Stage 1 Road Safety Audit

**Proposed Residential Development
Hanging Heaton, Dewsbury**

Vistry Partnerships (Yorkshire)

Doc Ref: TH/200391/RSA/1

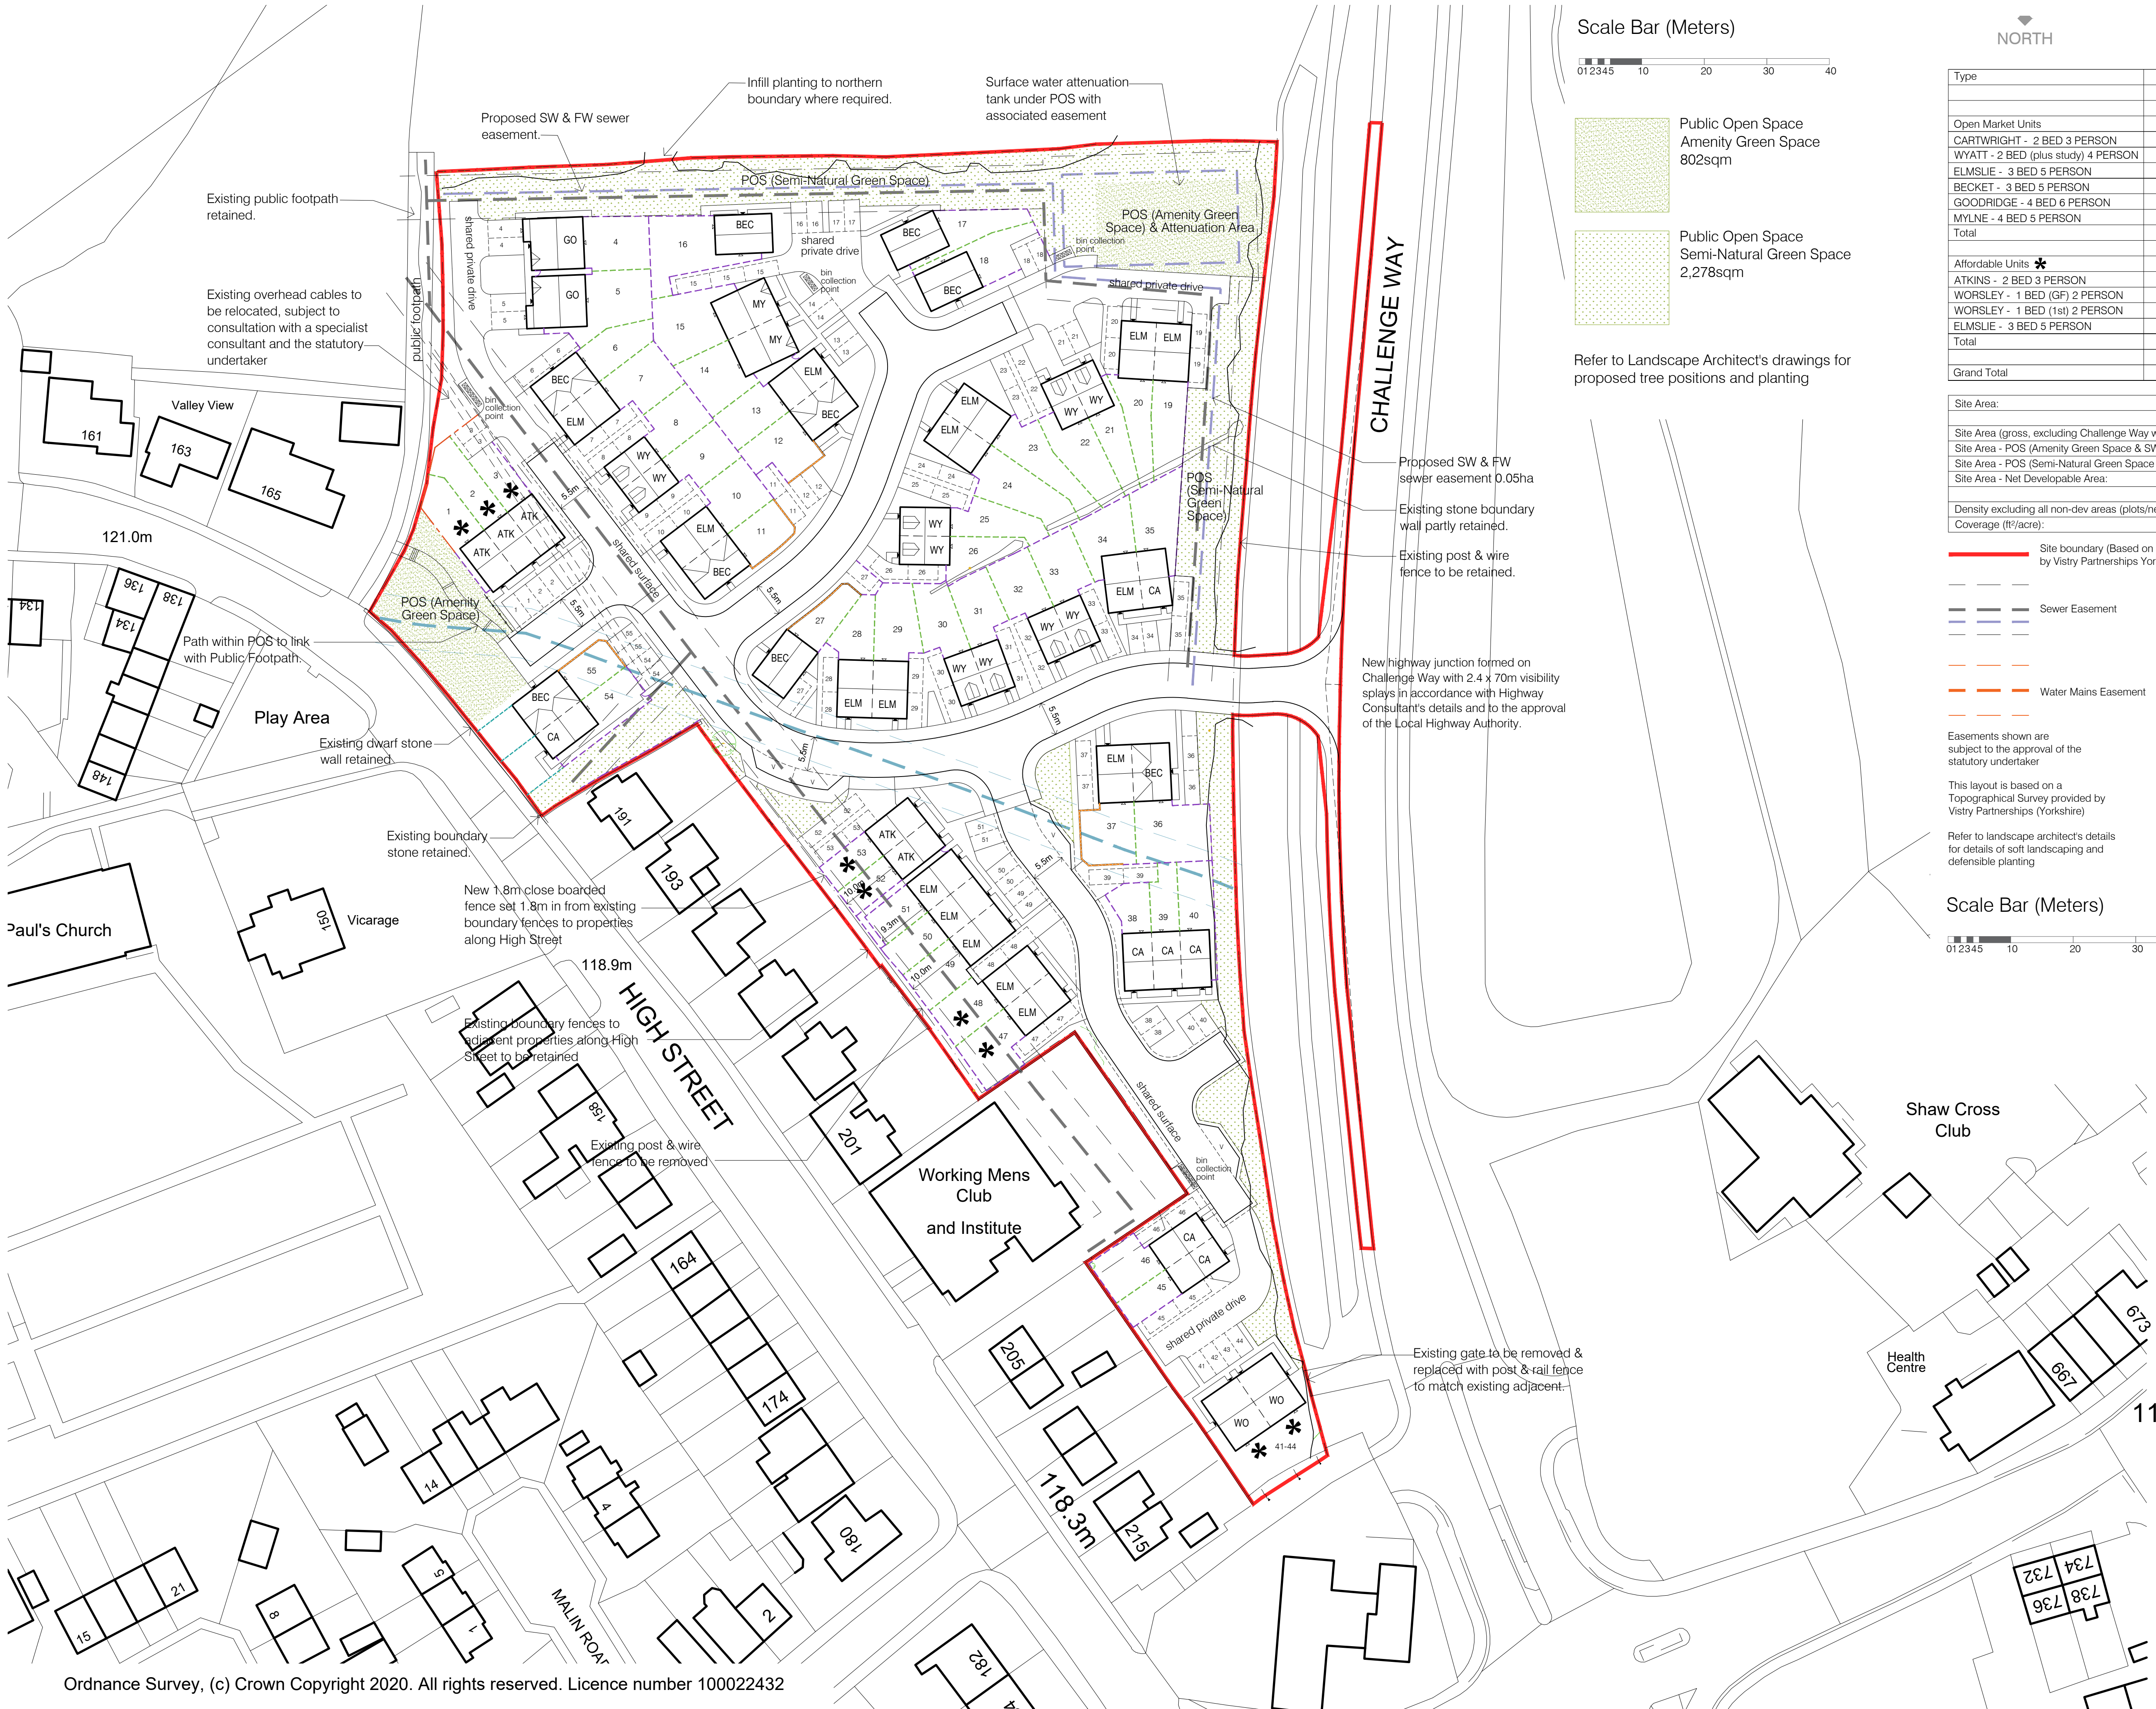
PROBLEM		1
Location:	Site Access	
Summary:	The form and type of the site access onto Challenge Way is not provided in detail	
Proposed SW & FW sewer easement 0.05ha New highway junction formed on Challenge Way with 2.4 x 43m visibility splays in accordance with Highway Consultant's details and to the approval of the Local Highway Authority.		
Drawing 301 Revision 5 does not provide sufficient detail of the geometry of the proposed site access for an appropriate assessment of its safe operation to be undertaken. The auditors are concerned that an access constructed to incorrect design parameters, taking account of mainline and side road vehicle flows, may lead to collisions and damage to property.		
RECOMMENDATION		
Provide details of the proposed site access in accordance with the appropriate design standards.

PROBLEM		2
Location:	Site Access Challenge Way	
Summary:	Potential for parked vehicles to obscure visibility from access

Currently there are Traffic Regulation Orders to prohibit car parking in the vicinity of the proposed site access along Challenge Way as it approaches the signalised junction of Challenge Way and Leeds Road. Once the access is operational, the audit team were concerned that there would be no provision to prevent car parking within the visibility splays (TBC – See problem 3) of the site access. This has the potential to result in an unsafe operation of the access due to reduced visibility.		
RECOMMENDATION		
Consider introducing or extending the Traffic Regulation Orders along Challenge Way across the site access and visibility splays, to ensure that clear visibility to oncoming traffic is maintained.

PROBLEM		3
Location:	Site access & internal highway network multiple locations	
Summary:	Visibility splays have not been clearly provided for the site access or internal highway layout.	
The audit team is concerned that without a plan demonstrating the visibility appropriate to the vehicle speeds along Challenge Way the proposed site access may operate unsafely. Currently the visibility splays are presented as “indicative” but meet the standard for 30mph. It is considered that, given to the proximity of the Challenge Way / Leeds Road signalised junction to the south it is necessary to provide visibility splays based on the 85th percentile vehicle speeds when determining the appropriate visibility splay at the site access. Excessive vehicle speeds require specific measures to be implemented and without further information it is unclear if this is the case here. Internally visibility splays must be provided in accordance with the internal highway design speed for the carriageway geometry. This should also include visibility along the internal carriageway bends to ensure that appropriate forward visibility is maintained. Appropriate visibility splays must be provided from driveways which access the internal network via vehicle crossover to ensure that pedestrians can be clearly seen.

PROBLEM		4
Location:	Site Access and Internal highway network	
Summary:	No swept path assessment has been provided	
The information provided does not include details of vehicle tracking at the site access, nor the internal highway network. It has therefore not been possible to assess the suitability of the highway in terms of vehicles passing safely. The auditors are concerned that without the swept path assessment information. It is not possible to determine whether the site access or internal network has been designed in such a way as to allow for the safe passing of vehicles. Typically, local design guides require carriageway widening on bends to allow two vehicles to pass when vehicle approach certain minimum centre line radii. It is evident that this has not been provided across the development as a whole. However, this does not necessarily mean the carriageway widening is required at all locations on the highway where there are centreline radii. It is also necessary to provide swept paths at turning heads and private drives to ensure that appropriate vehicle crossing measures can be provided.

RECOMMENDATION		
Provide additional information on vehicle speeds and visibility splays at the site access, junctions within the site and forward visibility splays on the internal carriageway radii where appropriate.

RECOMMENDATION		
Provide details of vehicle tracking across the development
